**KIRKLEES METROPOLITAN COUNCIL
INVESTMENT & REGENERATION SERVICE**

**DELEGATED DECISION TO DETERMINE APPLICATIONS FOR
CONSENT, AGREEMENT OR APPROVAL REQUIRED BY CONDITION**

Reference No:	2024/44/93036/E
Site Address:	Greenside Mills, Saville Road, Skelmanthorpe, Huddersfield, HD8 9EE
Description:	Discharge of details reserved by condition 17 (drainage) of previous outline permission 2018/91787 for demolition of existing buildings and structures and erection of residential development
Recommending Officer:	Louise Bearcroft

Application: 2024/44/93036/E

DRAWING No: ALT170724-202-01

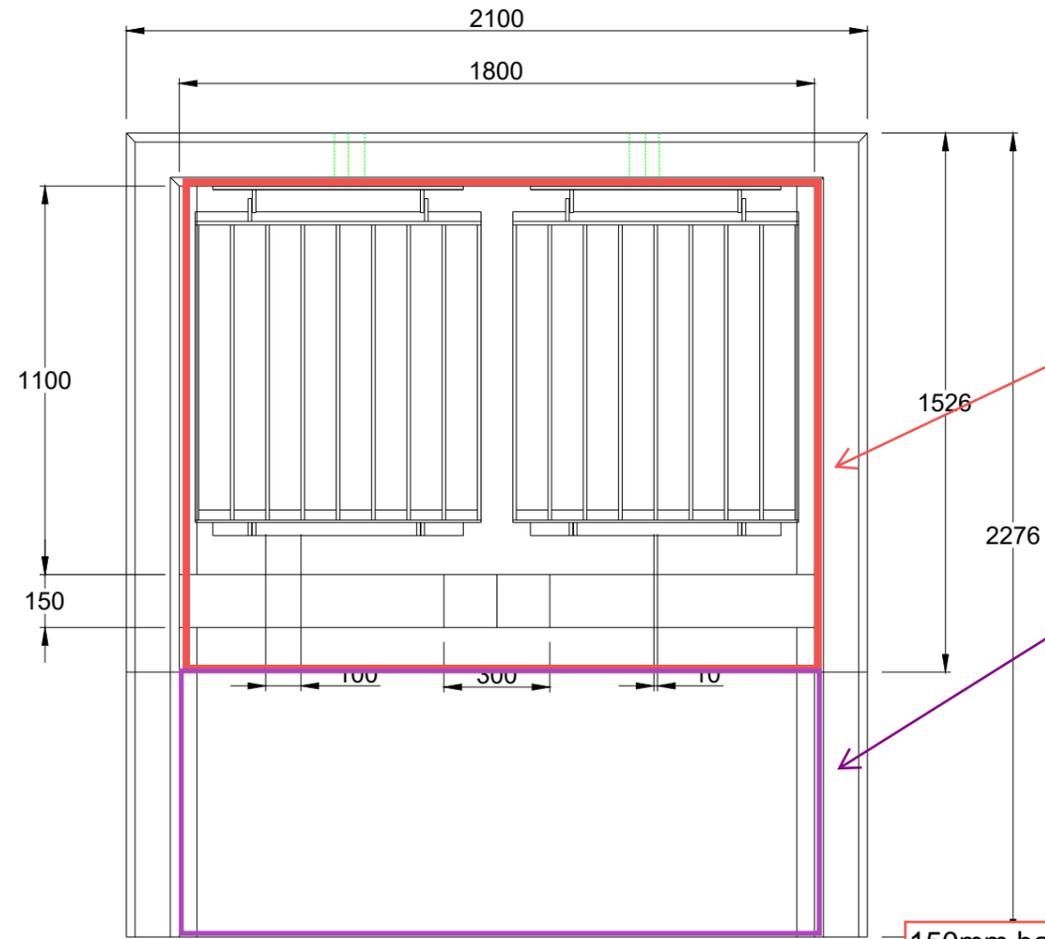
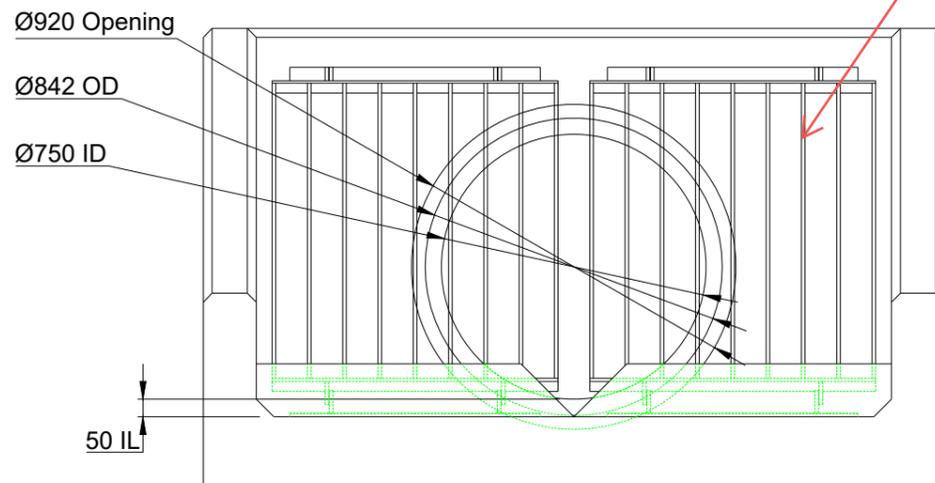
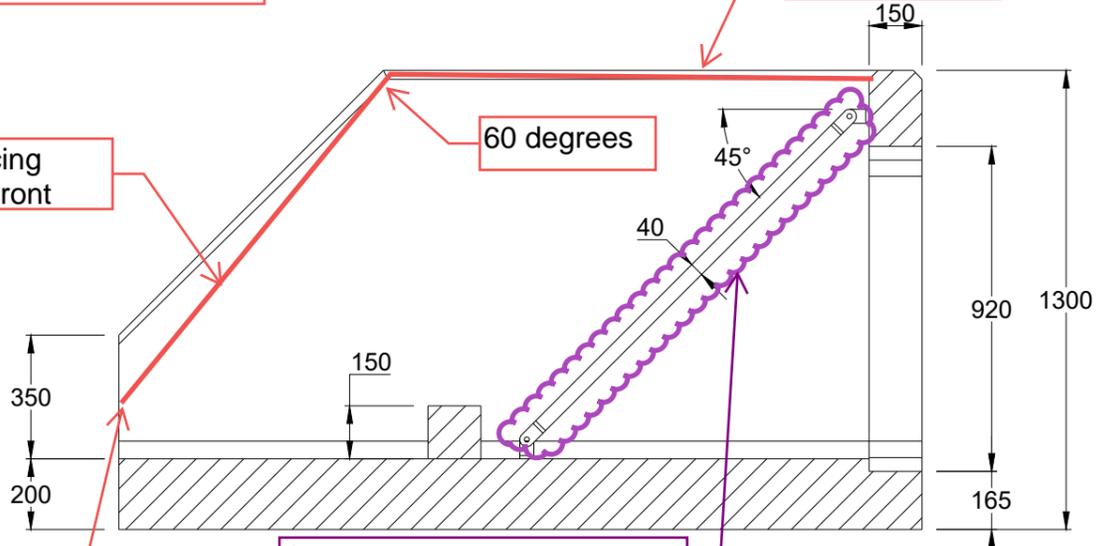
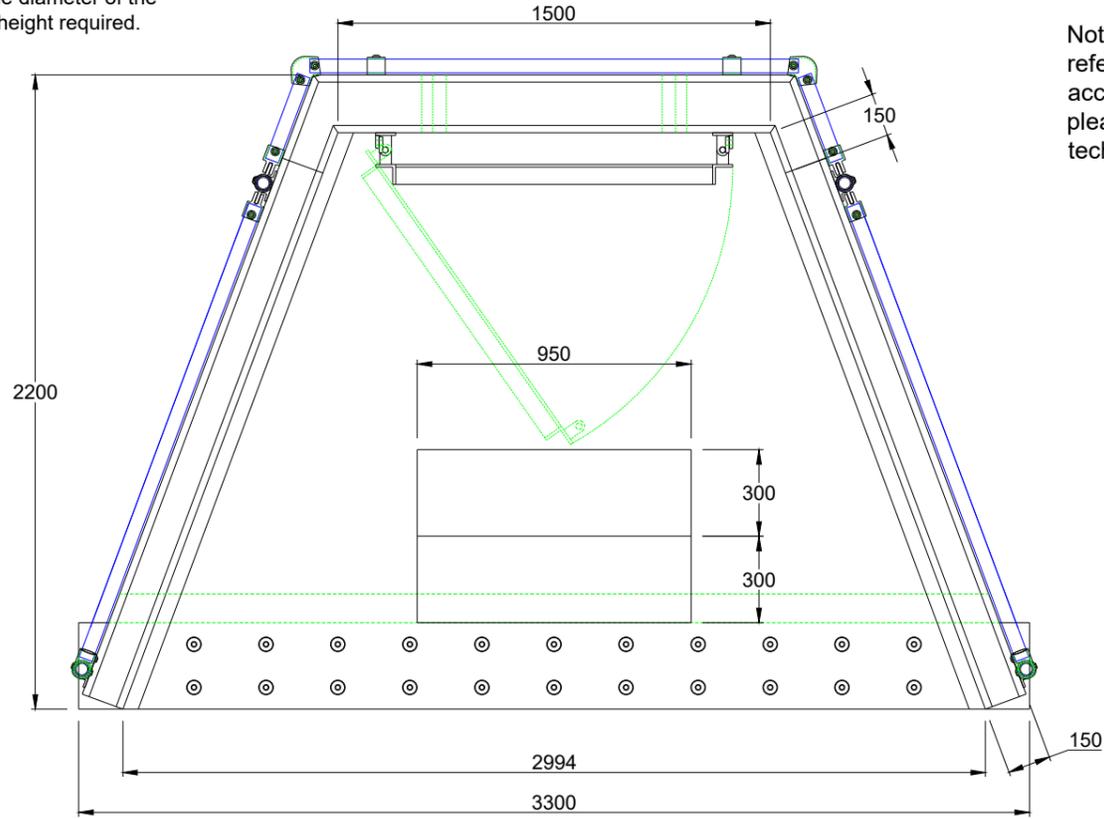
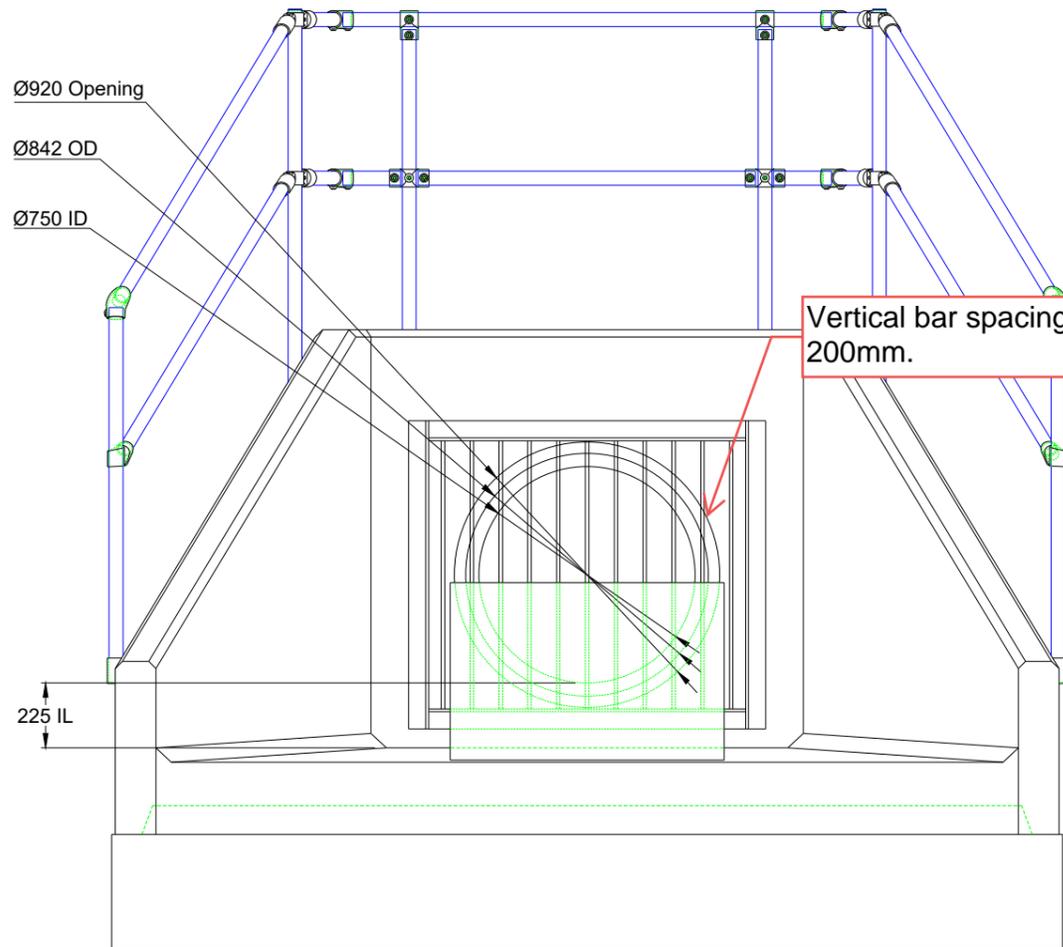
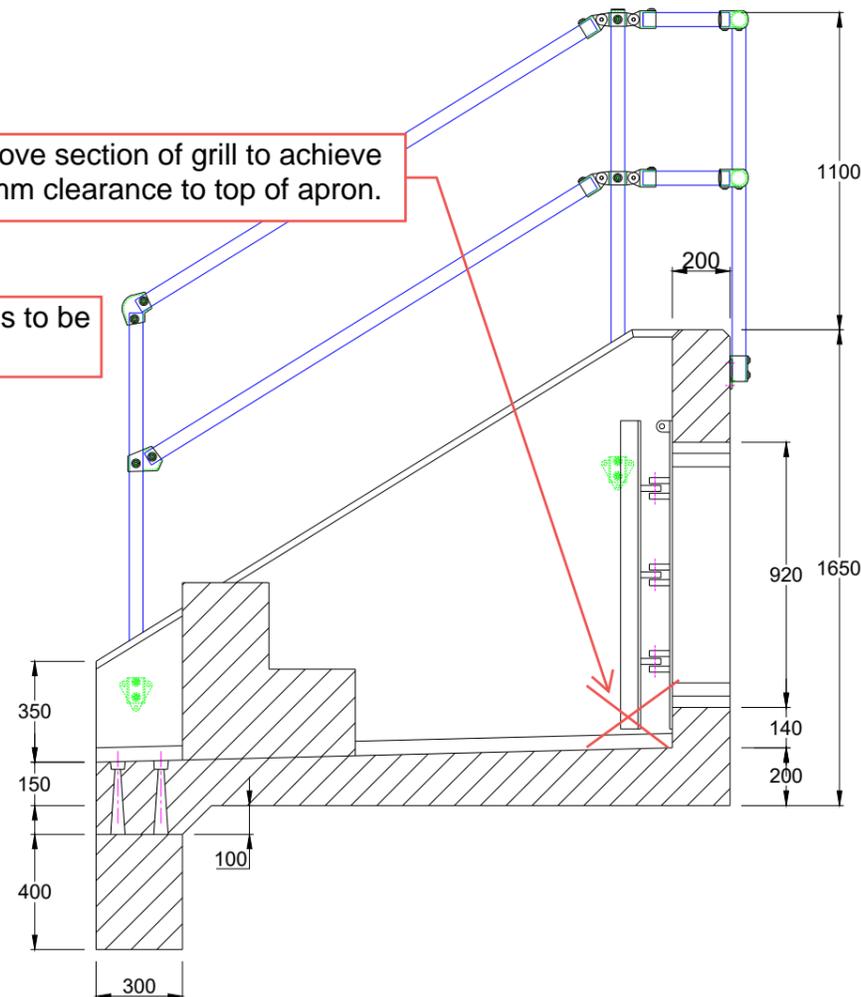
In response to these concerns the applicant submitted additional information which the LLFA note satisfies most of their requirements. However, the LLFA requested slight alterations and information regarding safety screen and trash screen design, with 150mm intervals for bars as a minimum of the angled screen and safety screen. They also recommend a 150mm clearance from the

bed to allow passage of small debris, and a significant horizontal section as an overflow for trash screens, with the design to look at how the screen will be maintained and a safe position for the operator.

In response the applicant updated the Drainage Detail Calculations to include updates to trash screen design. In their final comments dated 11/04/2025, the LLFA note this is acceptable to satisfy the condition and can now recommend that condition 17 is discharged.
